OBJECTION

Development Applications SSD 8925

The new Sydney Fish Market - Stage 2

EXISTING AND PROPOSED PUBLIC DOMAIN/ ACCESSIBLE AREAS

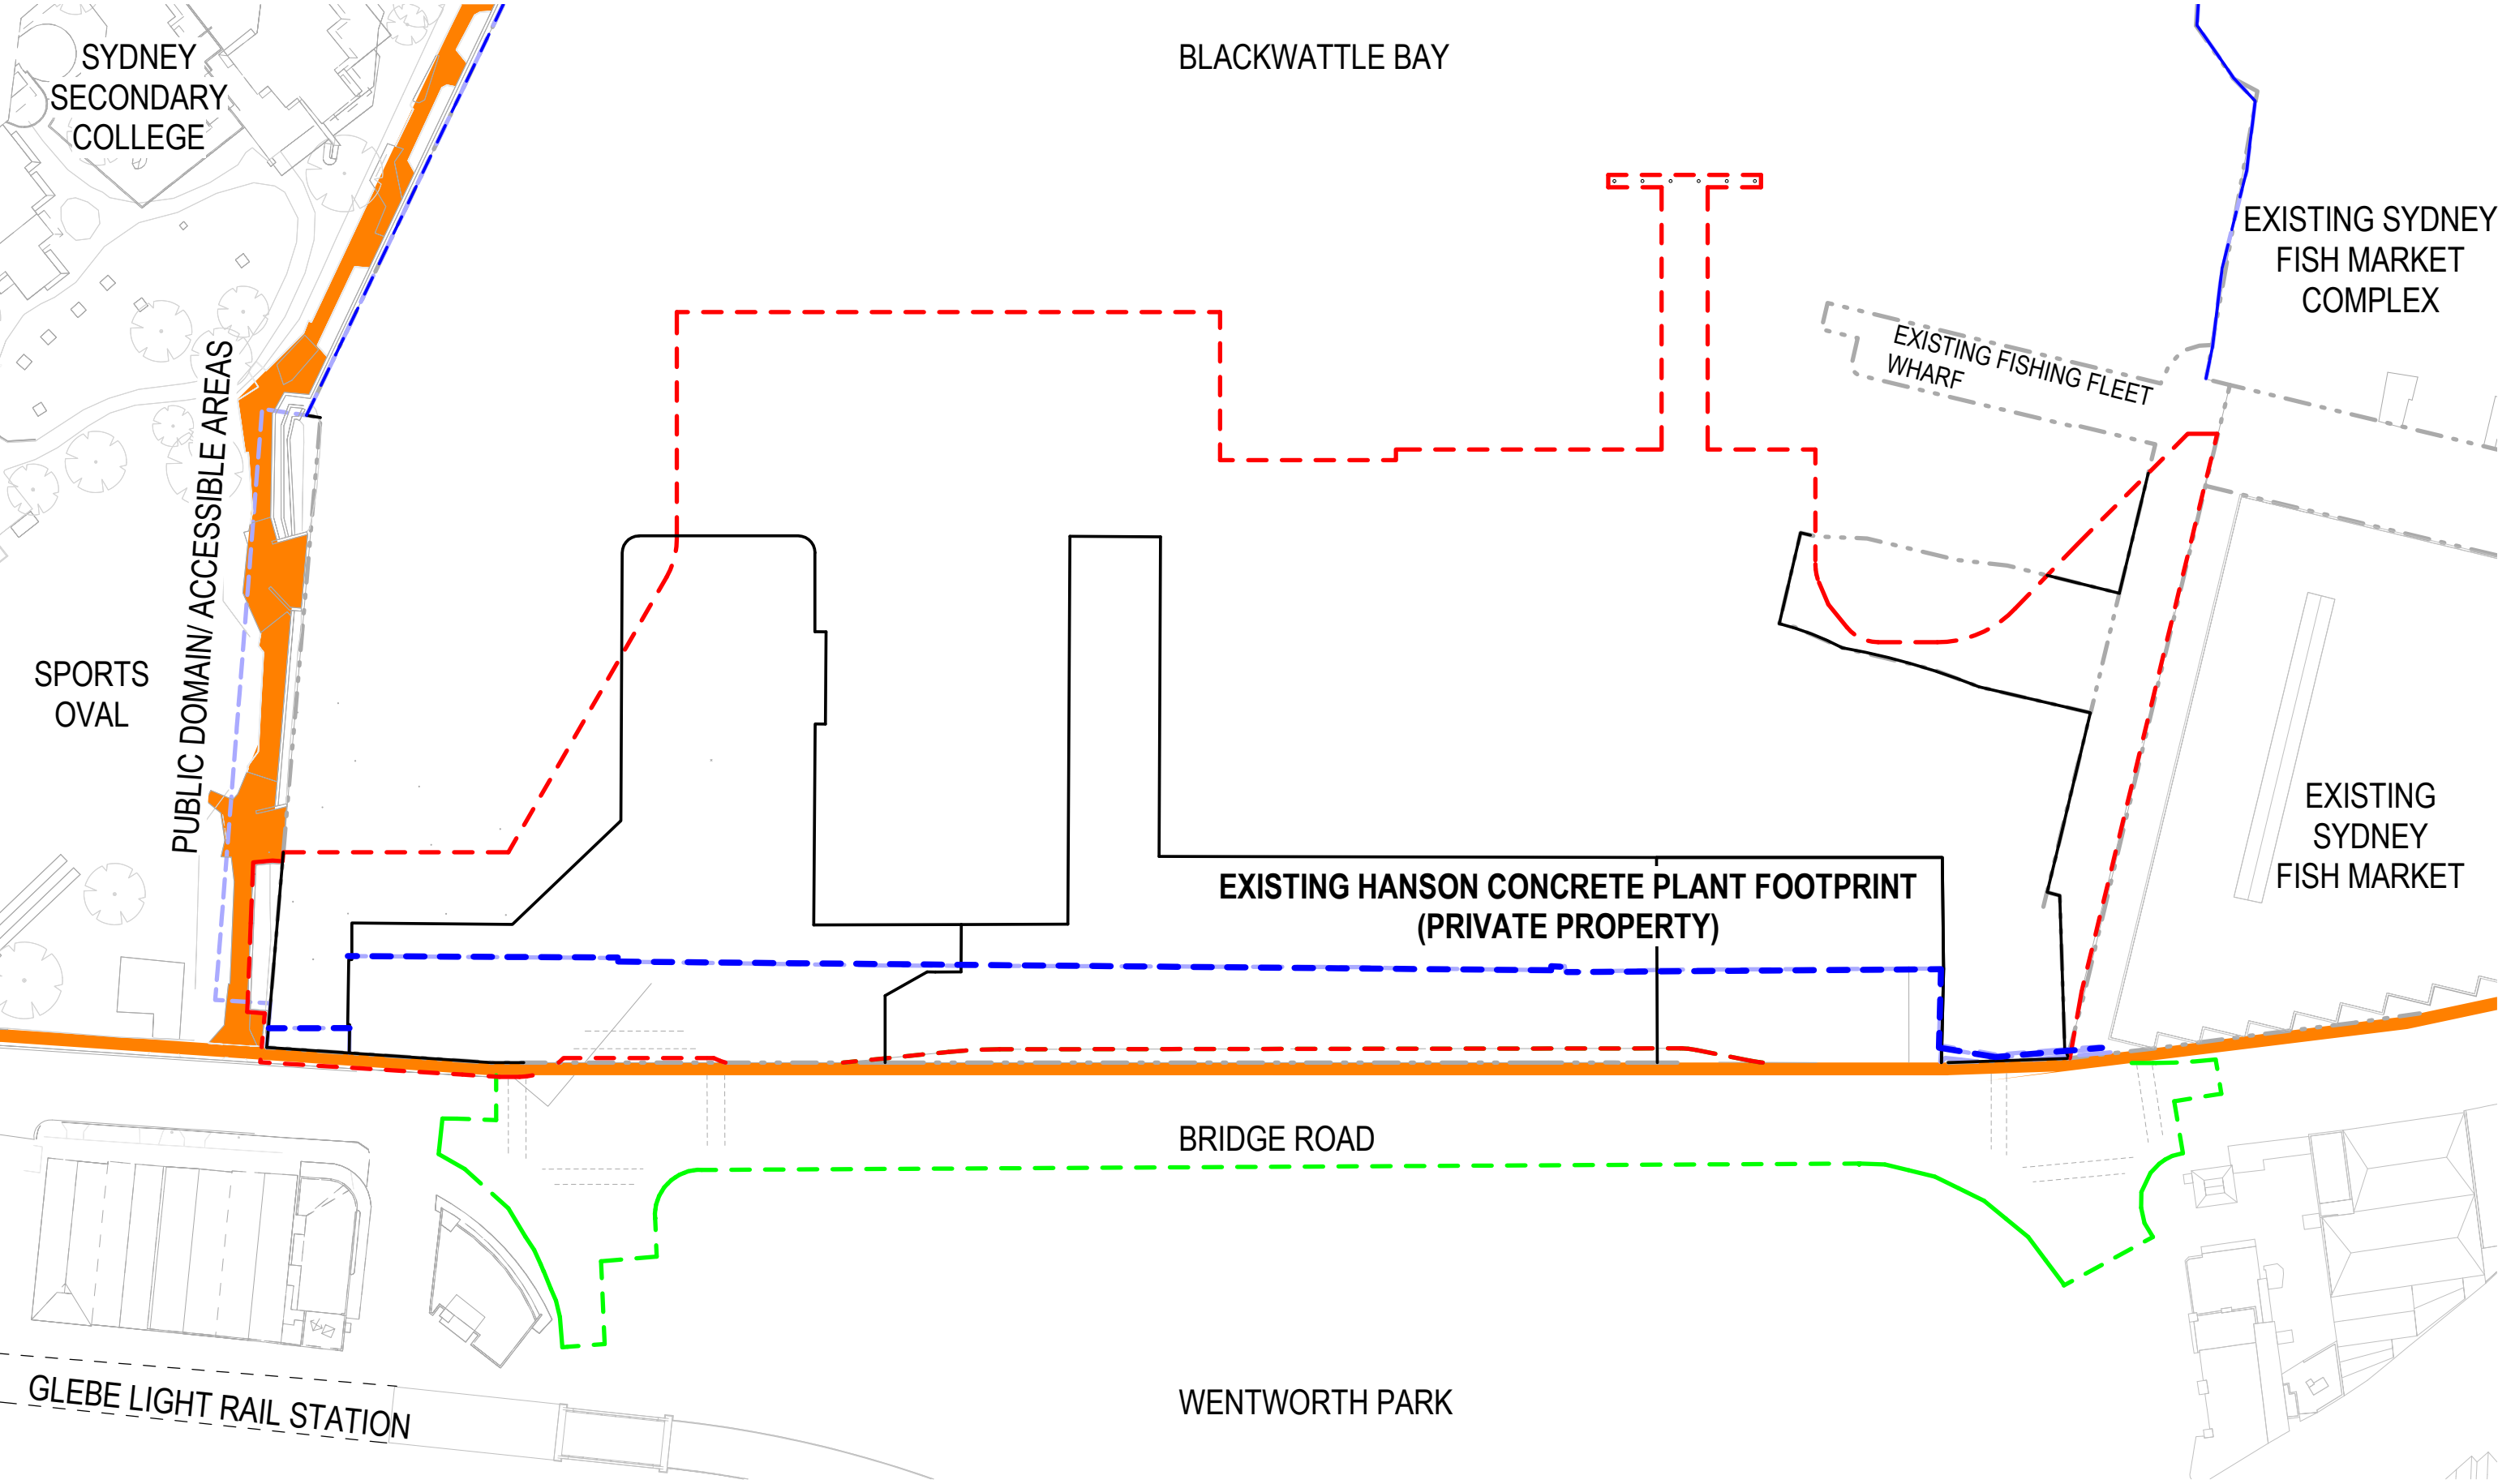
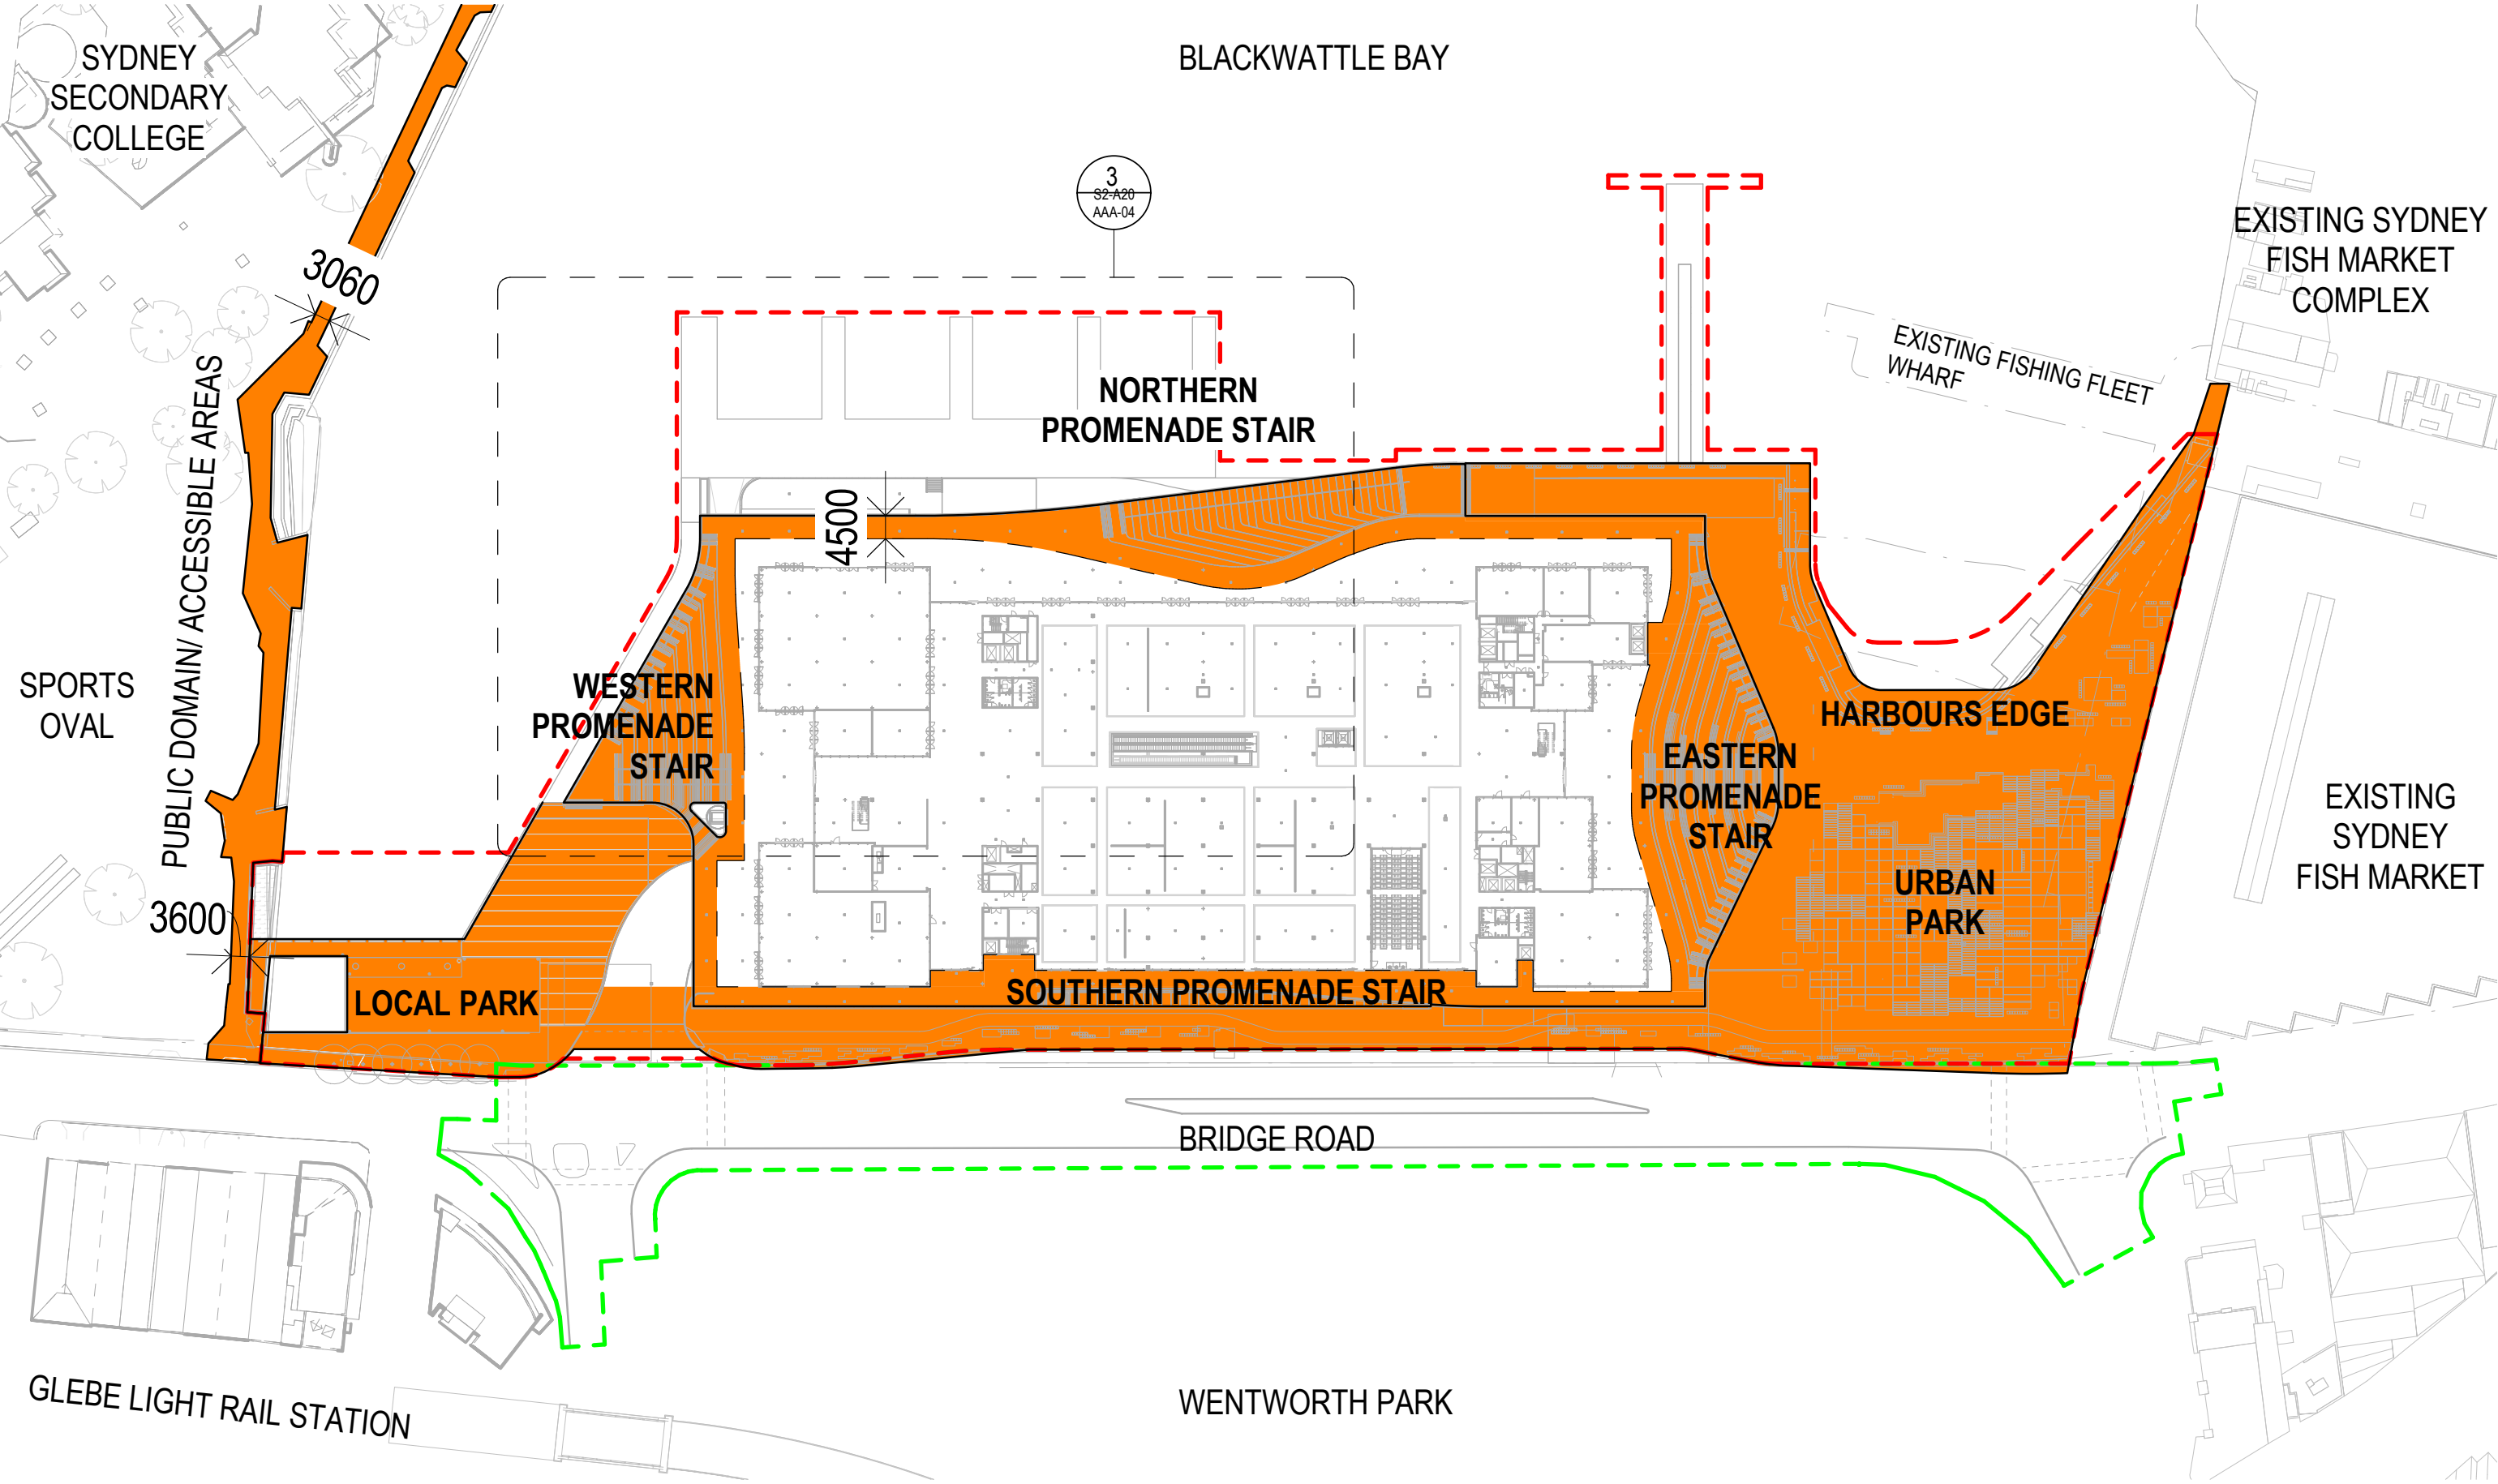
The promenade around the front of the SFM involves going up, along and then down two sets of steps. (*E.I.S. 3.5.3. p.29*).

TGS believes that the steps effectively discriminate against people who are reliant on wheelchairs. It will also create difficulties for parents and carers with children in prams, and people with young children riding bicycles, all using the Glebe Foreshore Walk in large numbers.

People using wheelchairs when travelling from Glebe must deviate from Bridge Road to access the lift that will take them up to the next level where they can re connect with the promenade. Those travelling in the reverse direction also need to access a lift down to the next level. This arrangement creates many potential problems for people with mobility impairment, both social and physical, as lifts break down, security risks increase, and most importantly, it is discriminatory.

TGS believes the current design of the promenade is not equitable, and that it appears to contravene the DDA. TGS objects to such a significant walk going through a building under the control of the SFM management. TGS also fears the SFM management could close the walk down if there were safety or security concerns.
